EA reference: PA-0013104/01
LPA reference: H17-0747-26

Date: 14 October 2026

**Proposed first floor extension to both incomplete dwelling and garage
15 The Reservoir, Surfleet, Spalding PE11 4DJ**

PROJECT: FIRST FLOOR EXTENSIONS
 ONTO EXISTING BUILDINGS
 SITE: 15, THE RESEVIOR,
 SURFLEET, Lincs.
 CLIENT:
 SCALES: 1:50, 1:100.
 DRAW NO: 15 RES 01-26

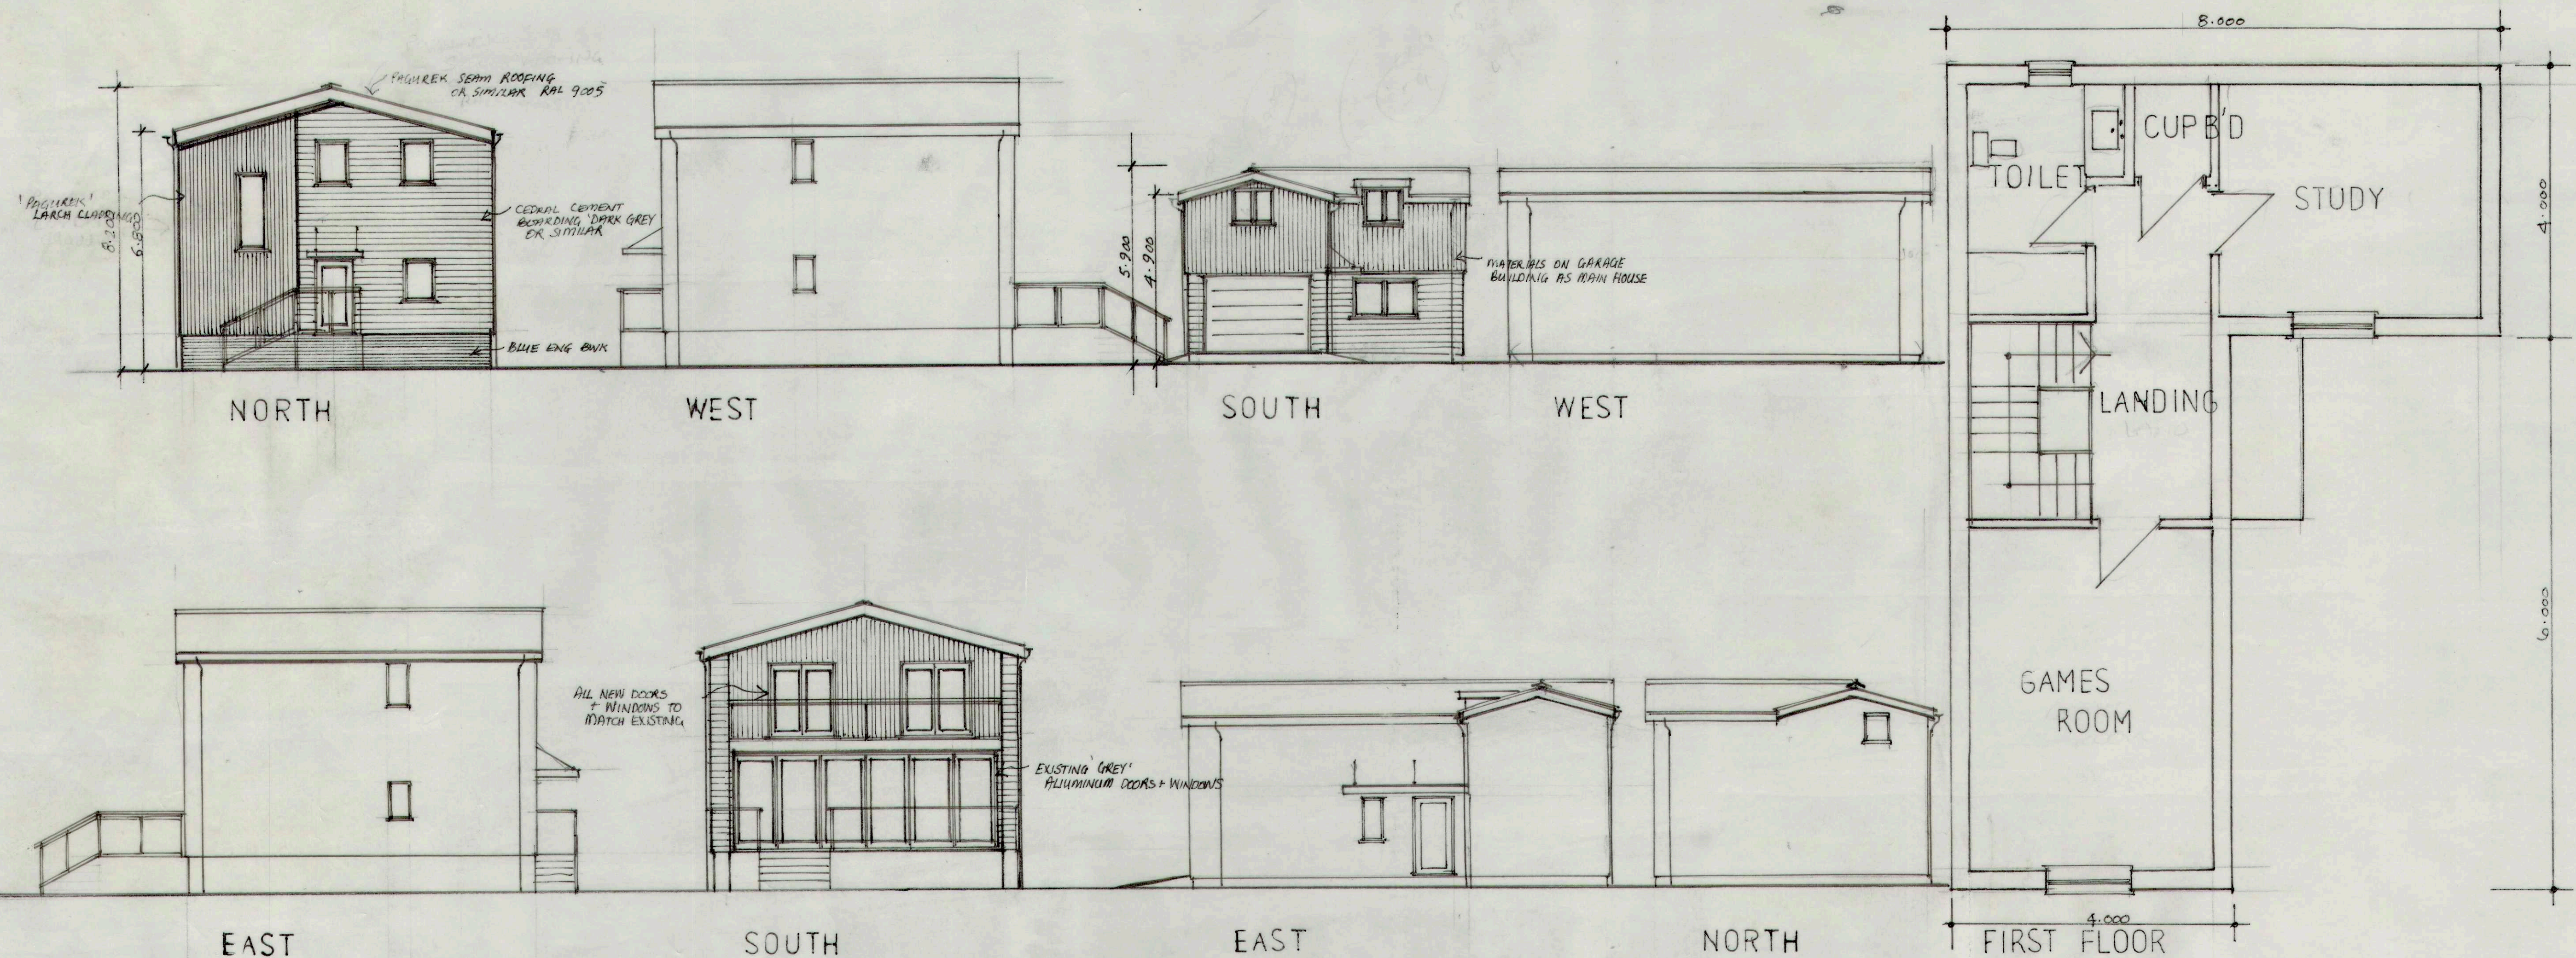
We note that the submitted elevation drawings do not show the inclusion of voids, however, as per the above, it is our understanding that the approval of elevation drawings under this application will not extinguish the requirement for the incomplete dwelling to comply with the flood risk requirements of permission H17-0216-21.
